Rezoning Transportation Analysis
Petition Number: Insert Zoning Petition #2021-285
General Location Identifier: 12105618

Revision Log:	Date	Description
	05-18-2022	First Review (WB)

JOB NO.: 2021-119  
 DRAWN BY: MDV  
 DATE: 12.22.21  
 SCALE: 1"=10'  
**SCHEMATIC SKETCH PLAN**  
**RZ.1**

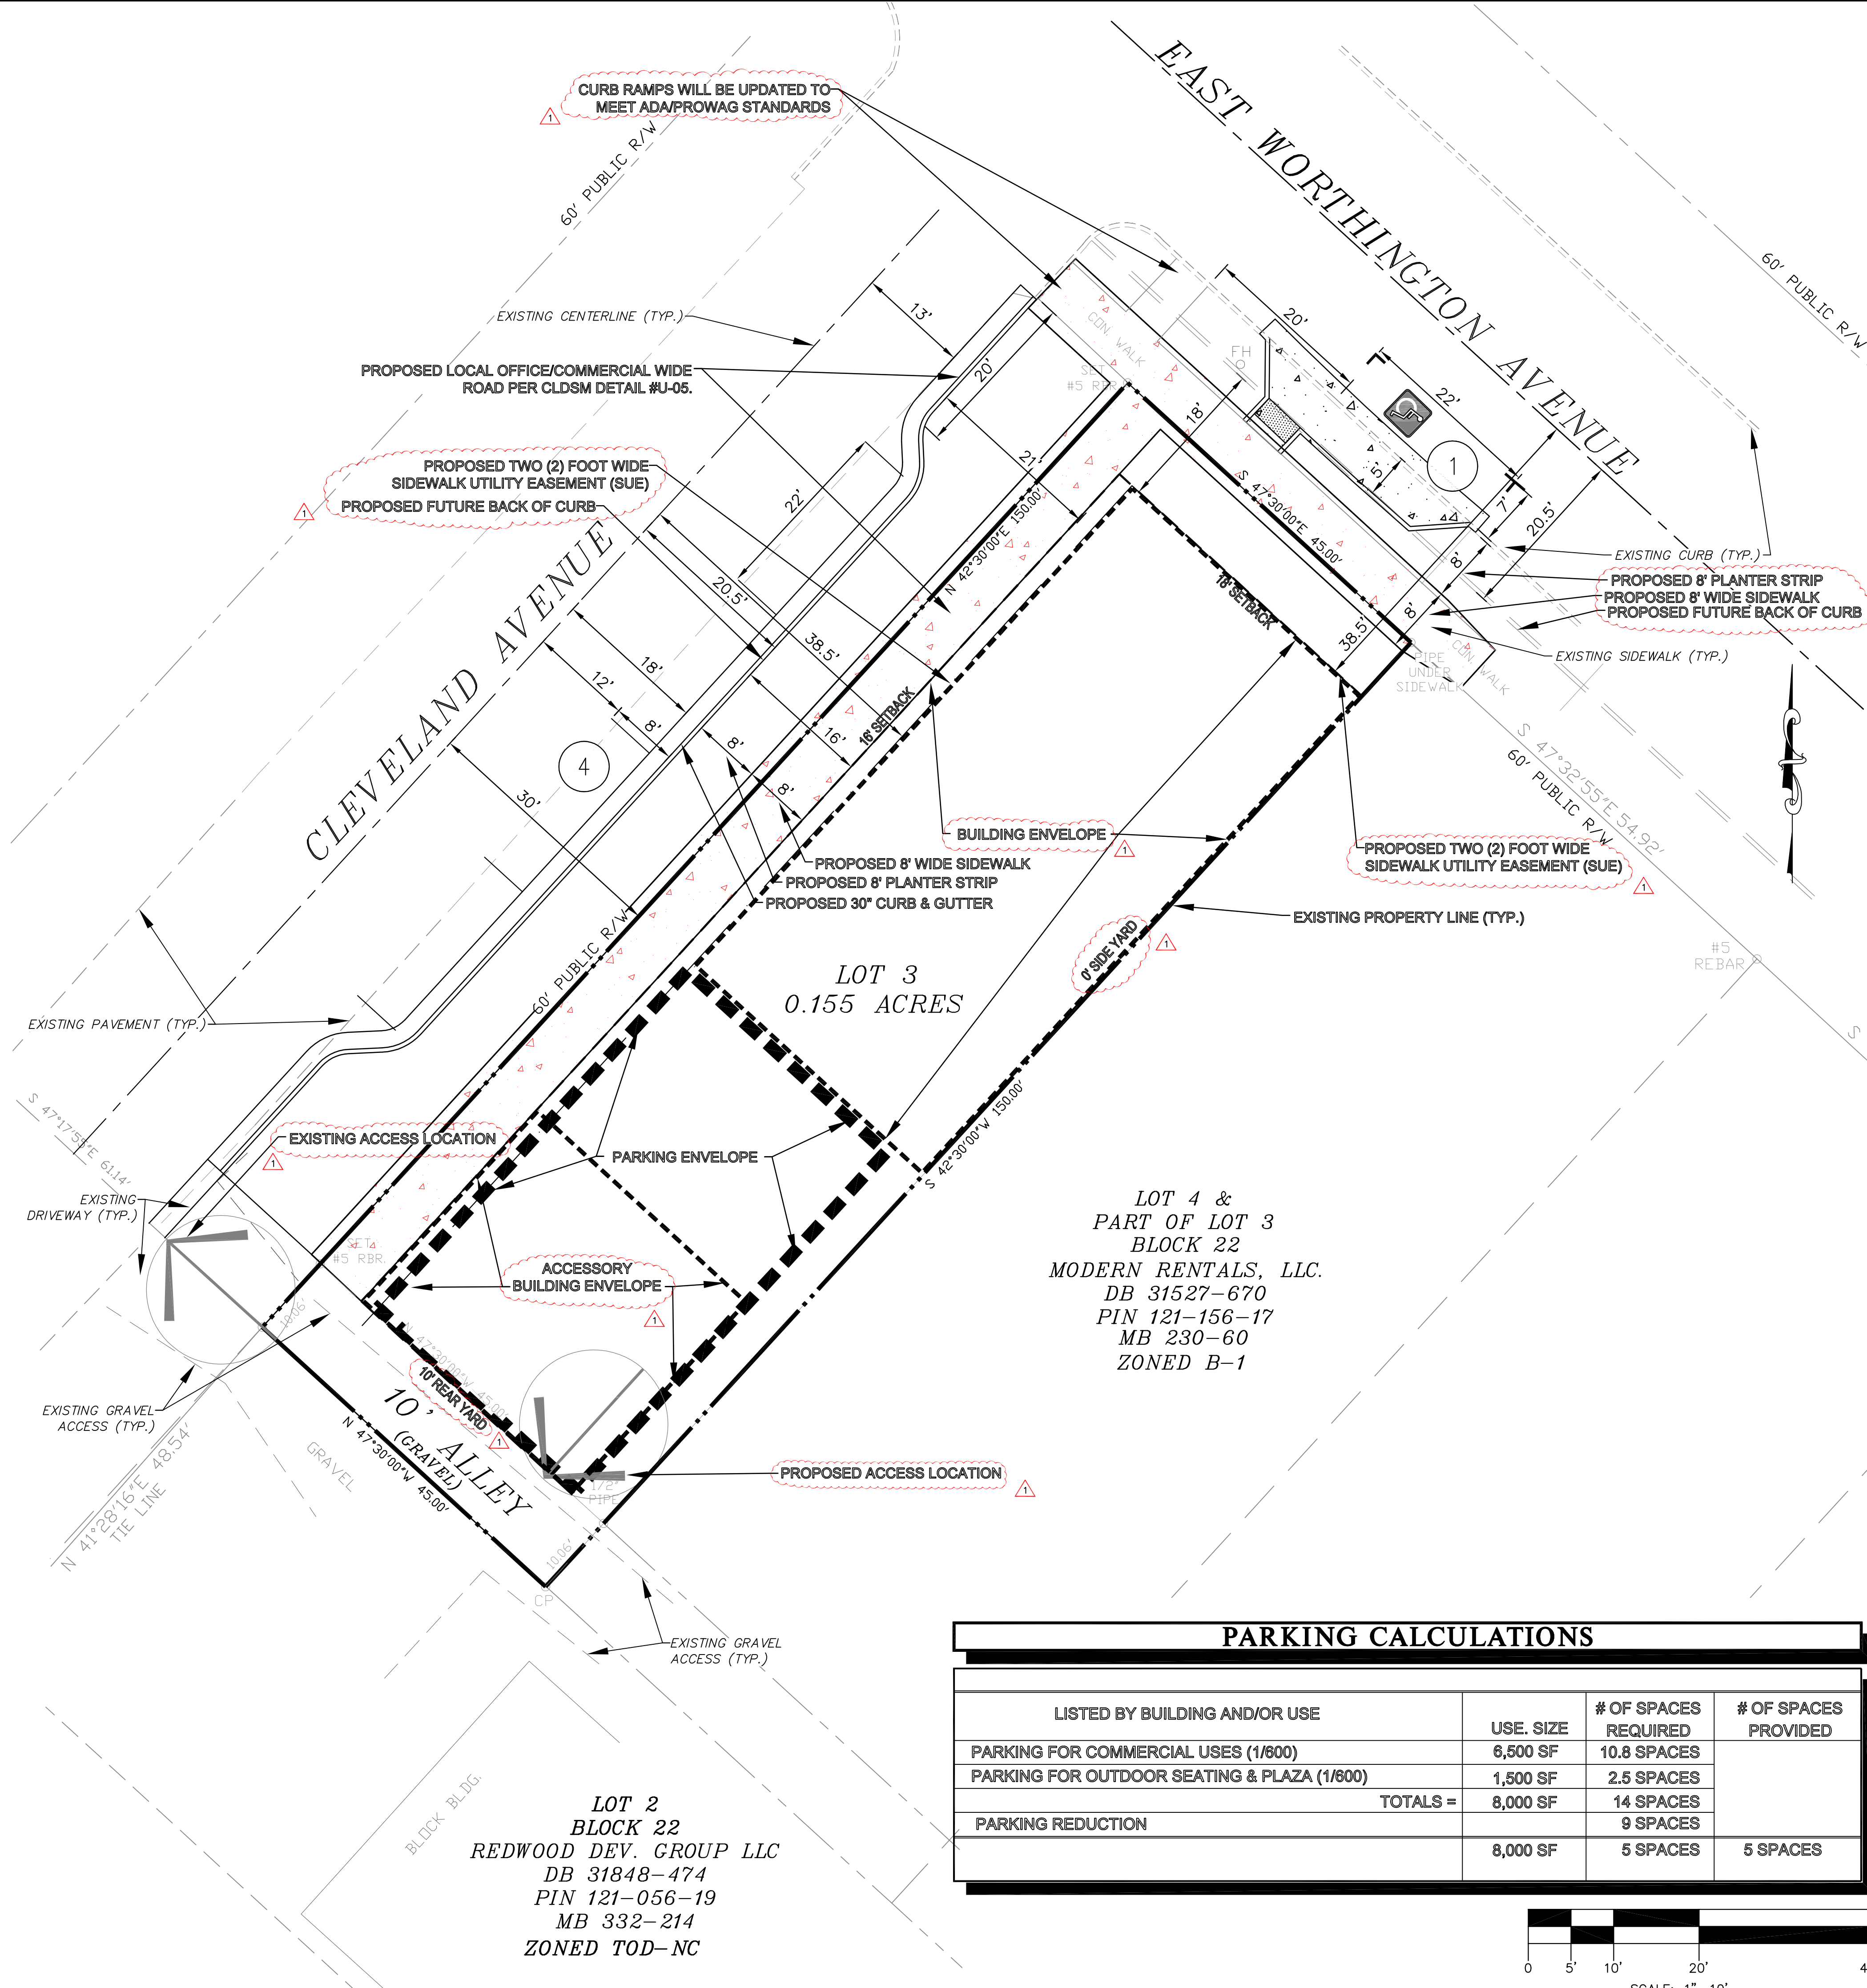
Site plan revisions are needed to meet ordinance requirements including, right-of-way dedication, ADA compliant pedestrian accommodations, and the addition of conditional notes. Further details are listed below.

1. **Curbline:** The proposed zoning district has a setback measured from back of the existing or proposed future curbline.
 - a. **Cleveland Avenue:** The future curb and gutter shall be located 20.5-ft from the centerline. This offset represents a Local Commercial Wide Typical section with on-street parking along the site's frontage.
 - b. **East Worthington Avenue:** The future curb and gutter shall be located at 20.5-ft from the centerline. This offset represents a Local Commercial Wide Typical section with on-street parking along the site's frontage. No relocation of the Curb & Gutter is required on East Worthington due to existing mature trees; however, plans must label and dimension the future location.

Label and dimension the curb and gutter from the centerline for each road on the site plan.

2. **Traffic Study:**
 A Traffic Impact Study (TIS) is not necessary for the complete review of this petition due to the site generating less than 2,500 daily trips. If during the permitting process the site generates more than 2,500 daily trips, then a traffic study will be required.
3. Revise site plan and conditional notes to label and dimension the East Worthington Avenue right-of-way from the road centerline. The site plan shall label and dimension the right-of-way from the road centerline.
4. Revise site plan and conditional notes to label a 2-ft sidewalk utility easement (SUE) 2-ft behind the future back of sidewalk for Cleveland Avenue and East Worthington Avenue (50.5-ft from the centerline).
5. Revise site plan and conditional notes to commit to installing ADA compliant curb ramps at the Cleveland Avenue and East Worthington Avenue intersection.

6. Revise site plan and conditional notes to commit to construct an 8-foot planting strip, and 8-foot sidewalk on East Worthington Avenue per Chapter 19 and CLDSM U-05A. The site plan shall label and dimension both items from the back of curb and gutter and road centerline.
7. Revise site plan to identify the proposed access to the proposed parking identified on the site plan.
